BANBURY PHASE 3, LAND TO THE NORTH-EAST OF JUNCTION 11, M40 - BANBURY, OXFORDSHIRE:

PROPOSED MIXED-USE DEVELOPMENT

REVIEW OF TRANSPORT ASSESSMENT

REVIEW DATE: 13TH SEPTEMBER 2021

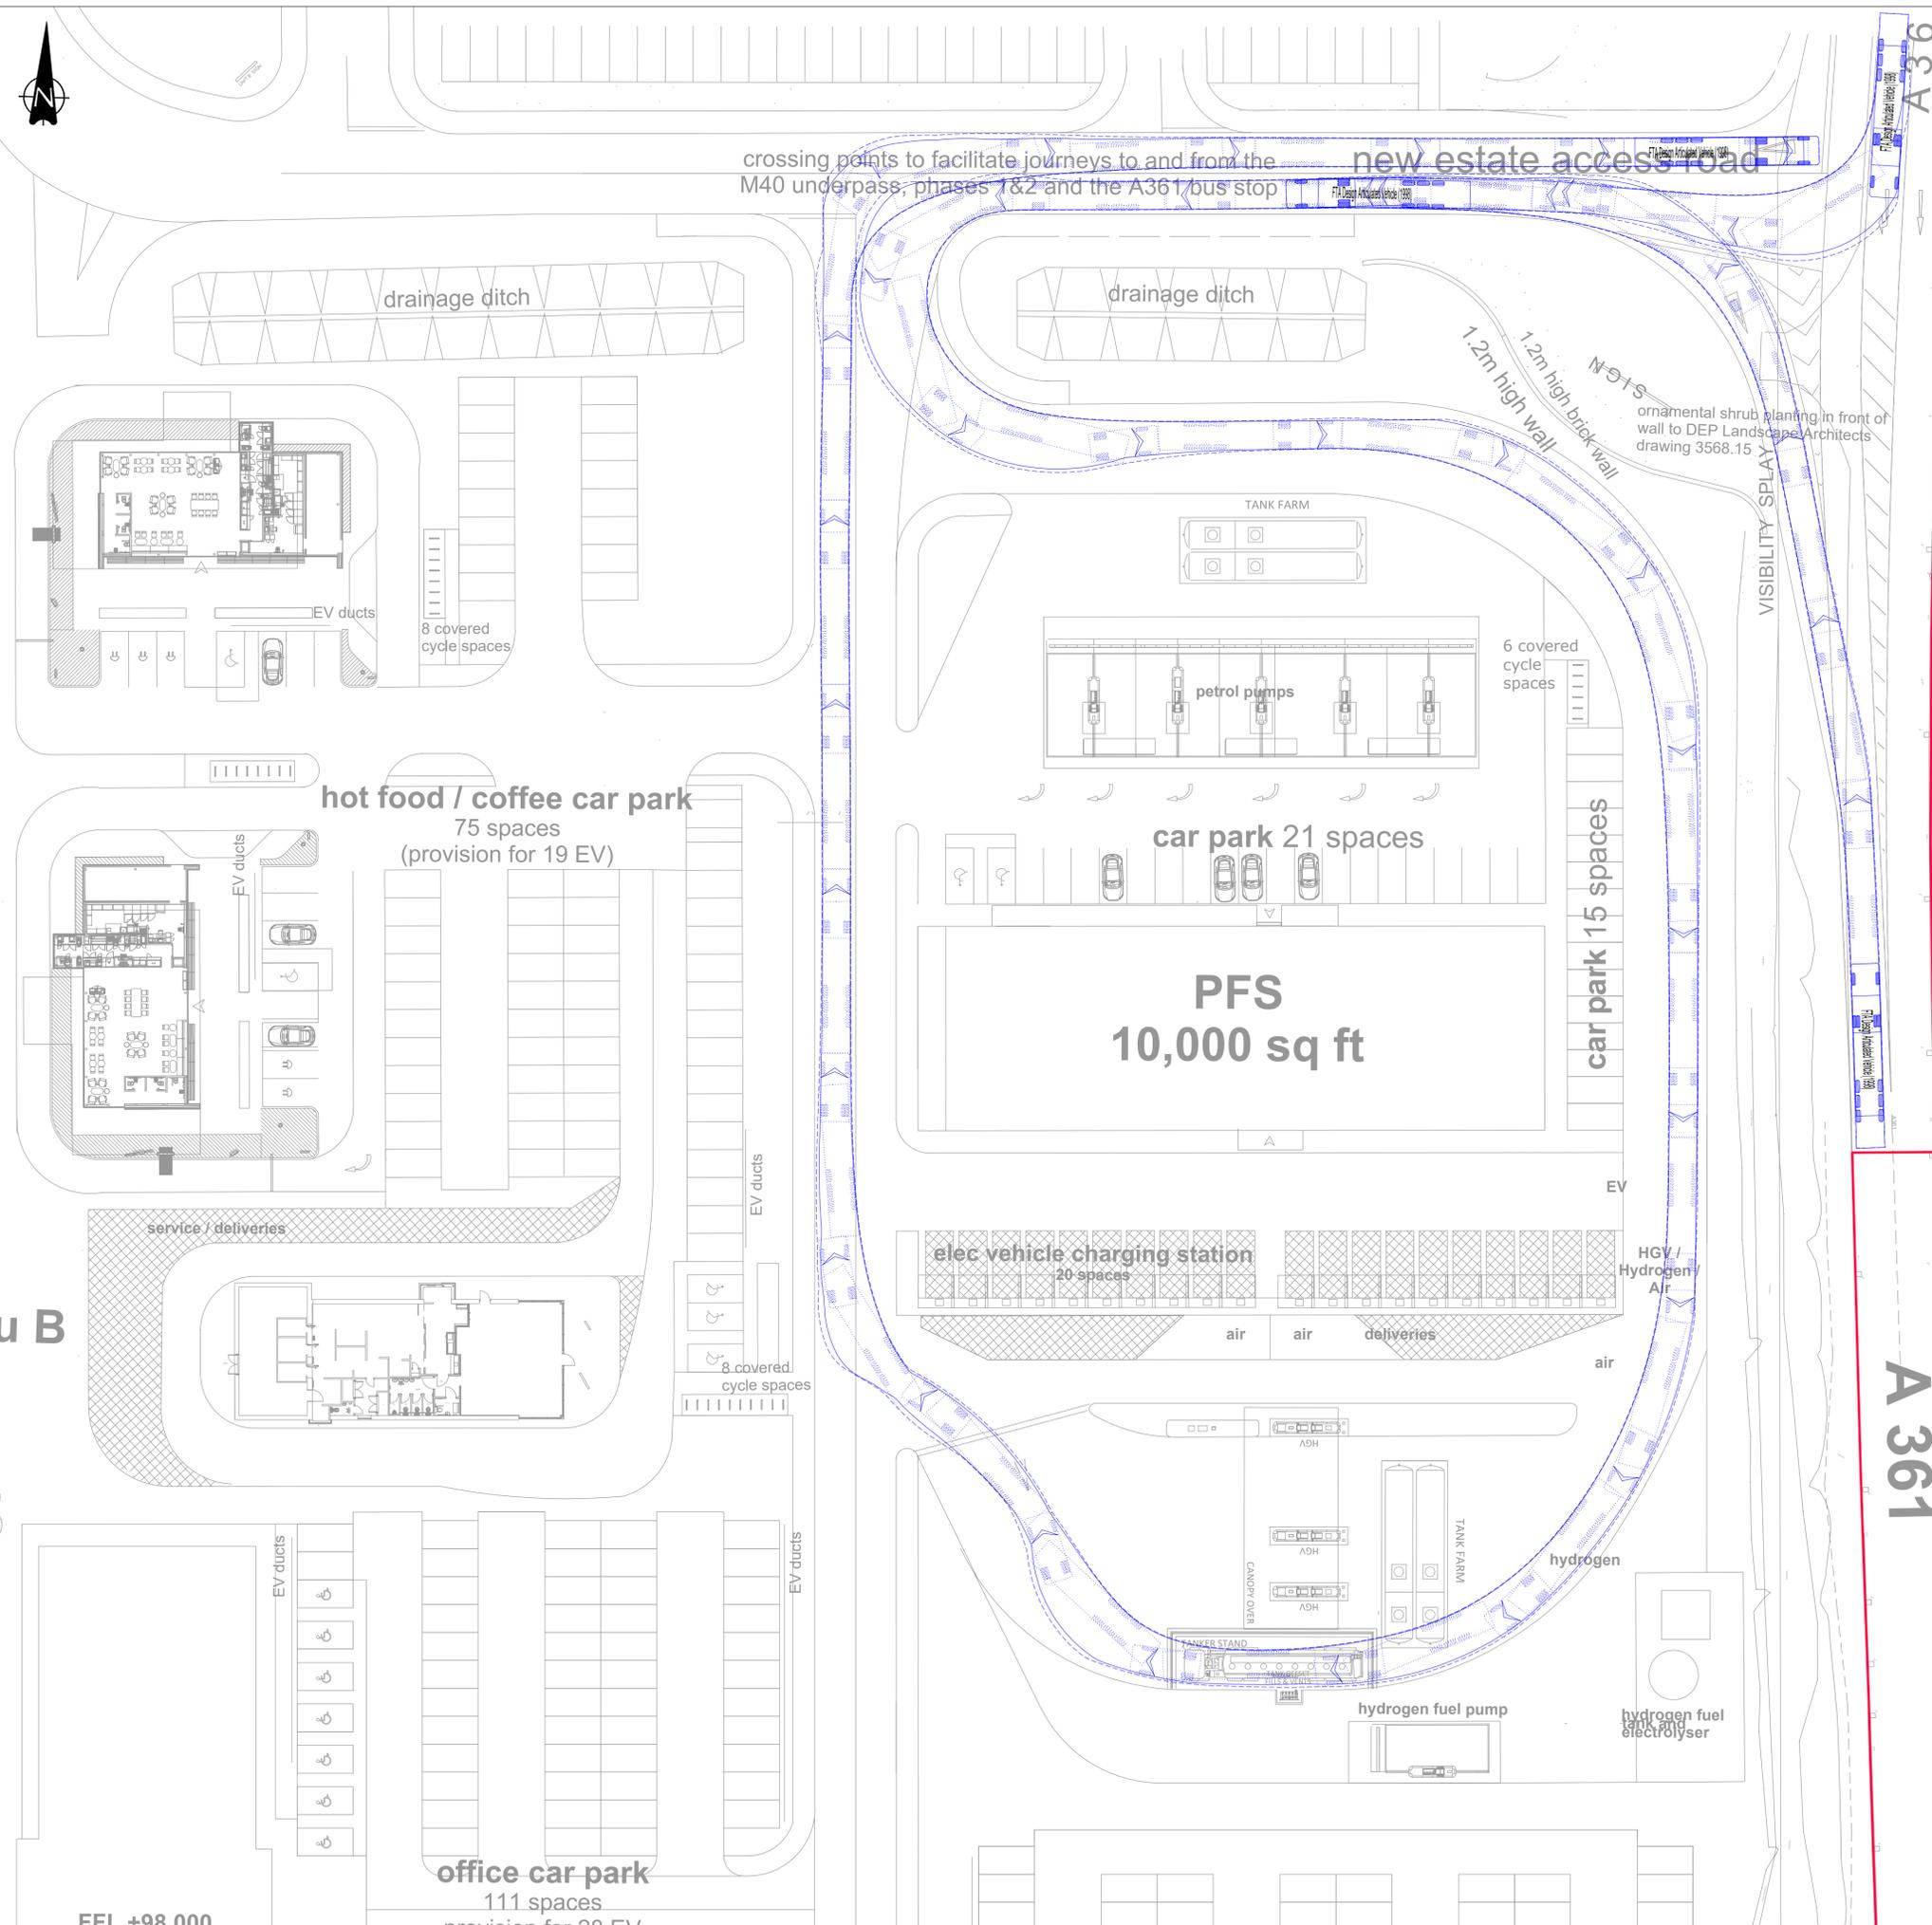
The internal estate road is 7.3m with 2m wide footpaths either side. No SWEPT path analysis to show large vehicles, including buses, can manoeuvre safely on site was provided. Please supply the swept path analysis exercises.

PM Peak Development Trip Distribution (New Trips)

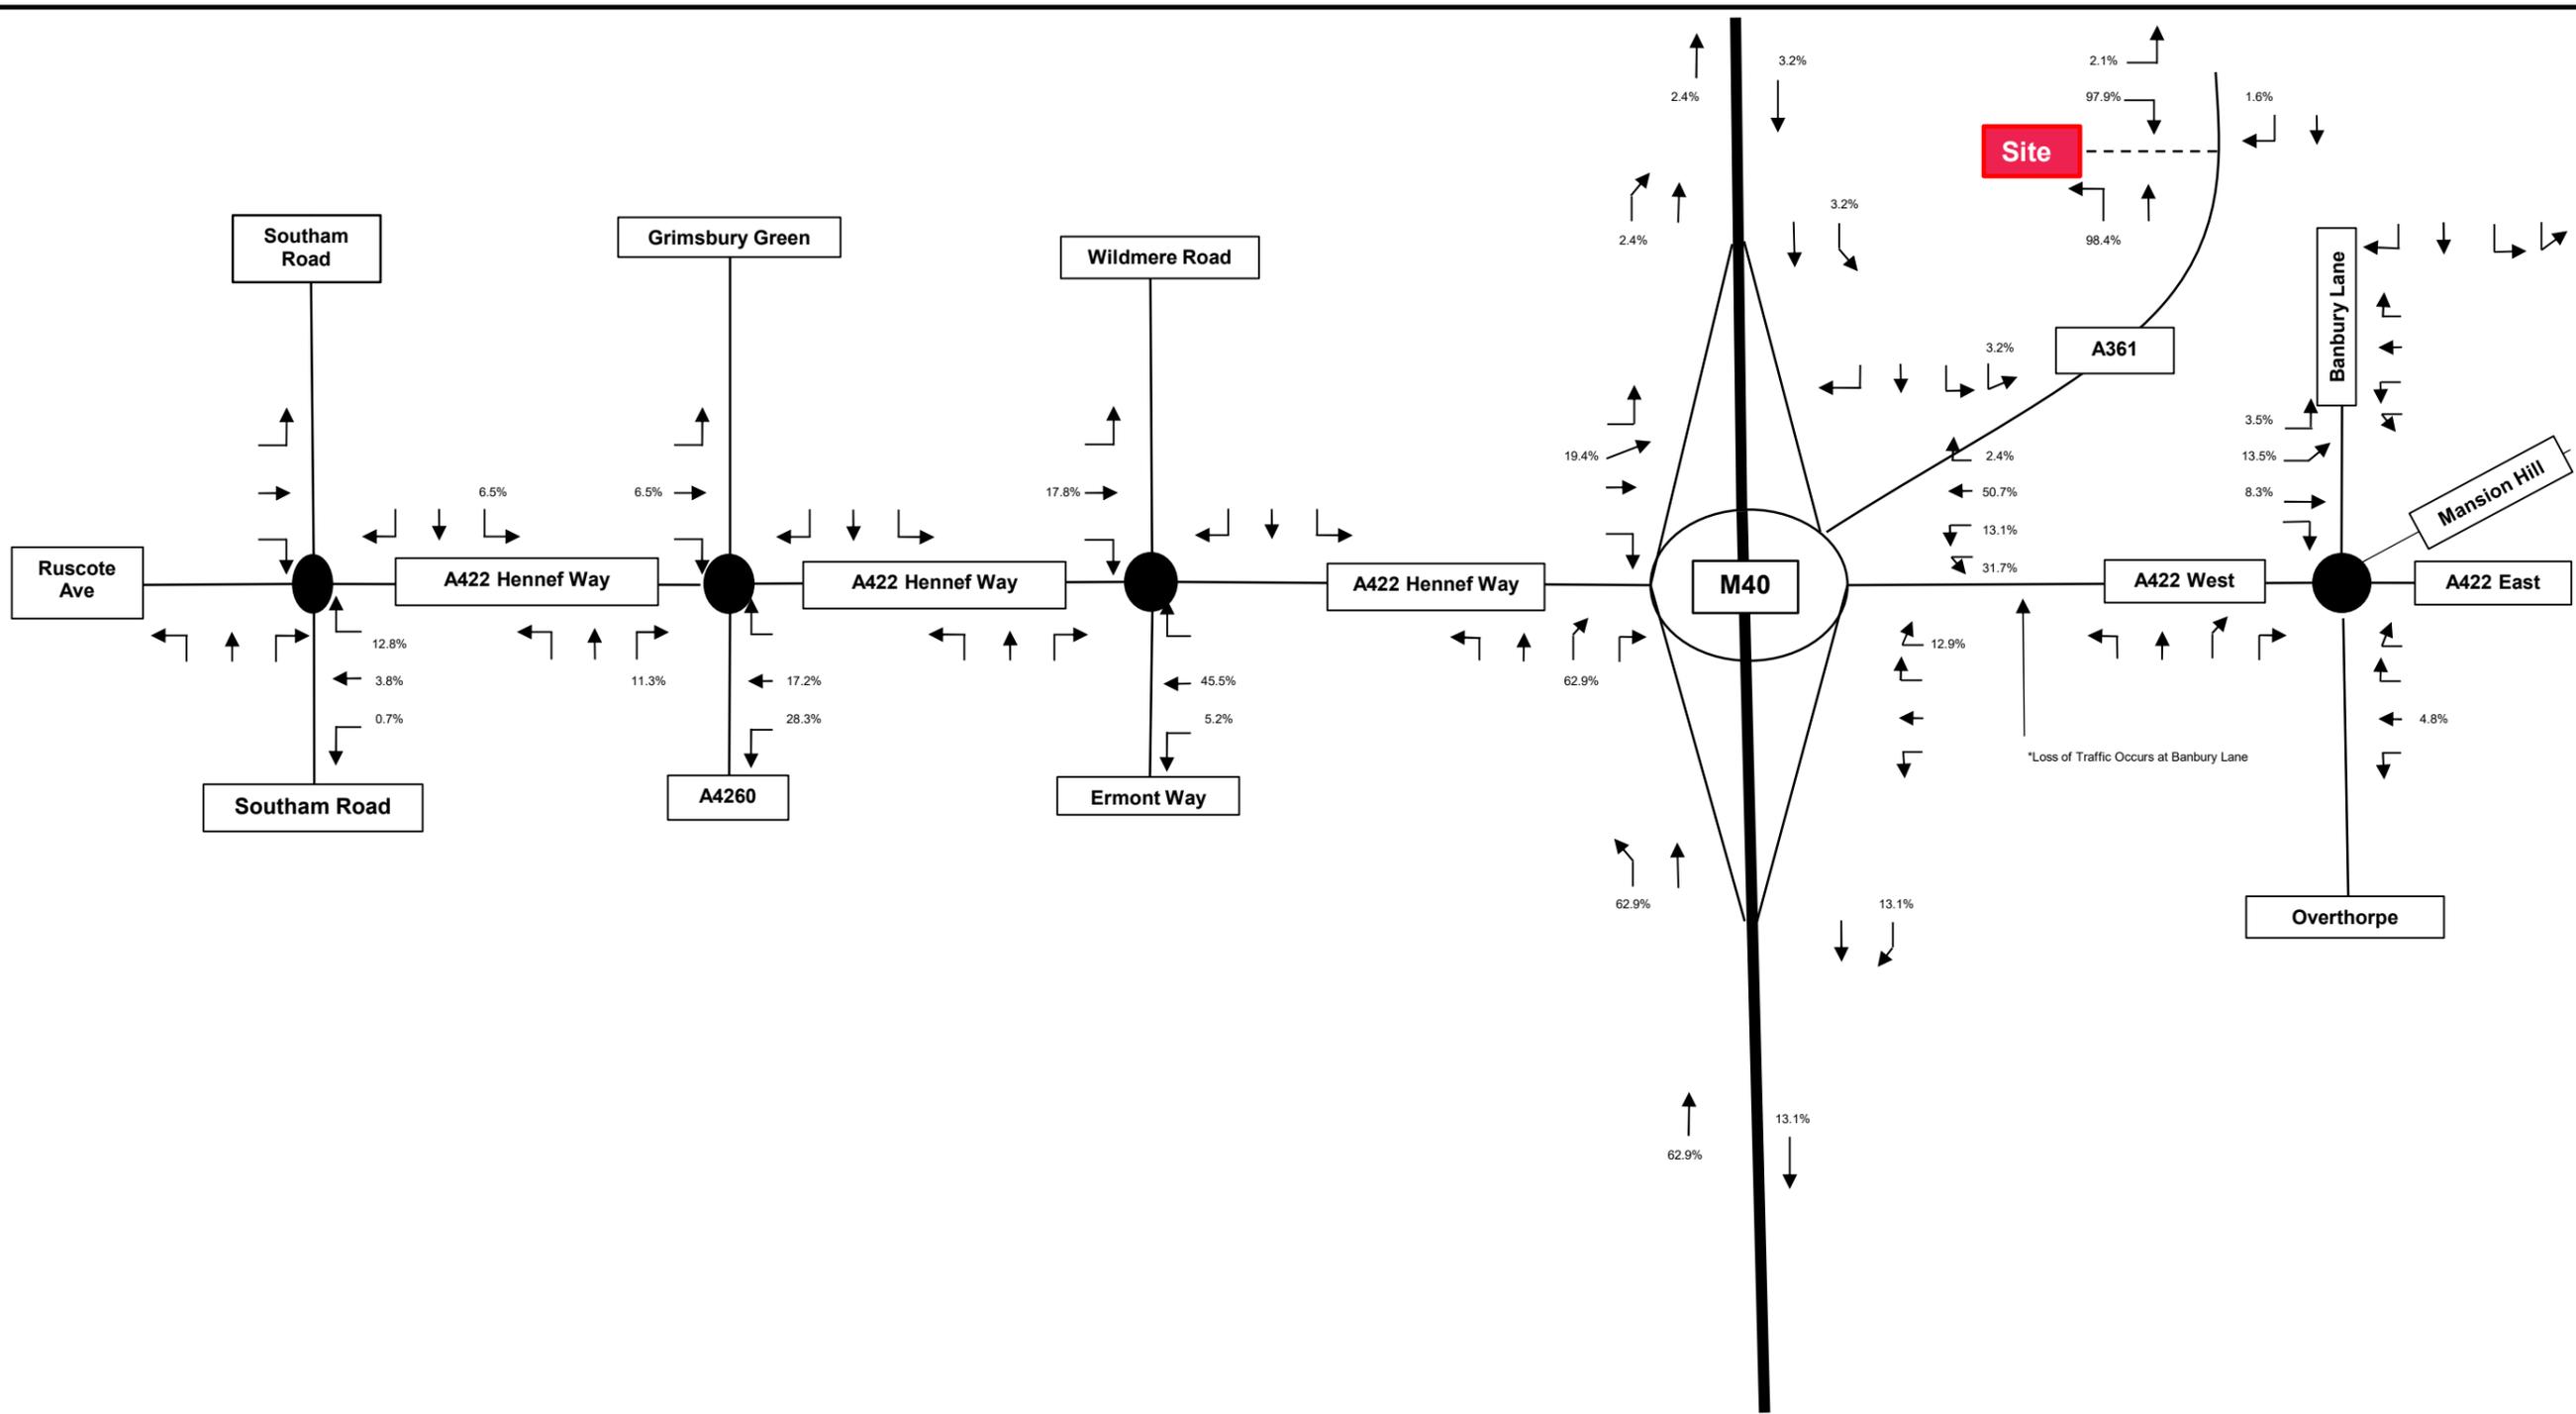
WNC Comment 5: A distribution flow diagram with the percentage distribution is required.
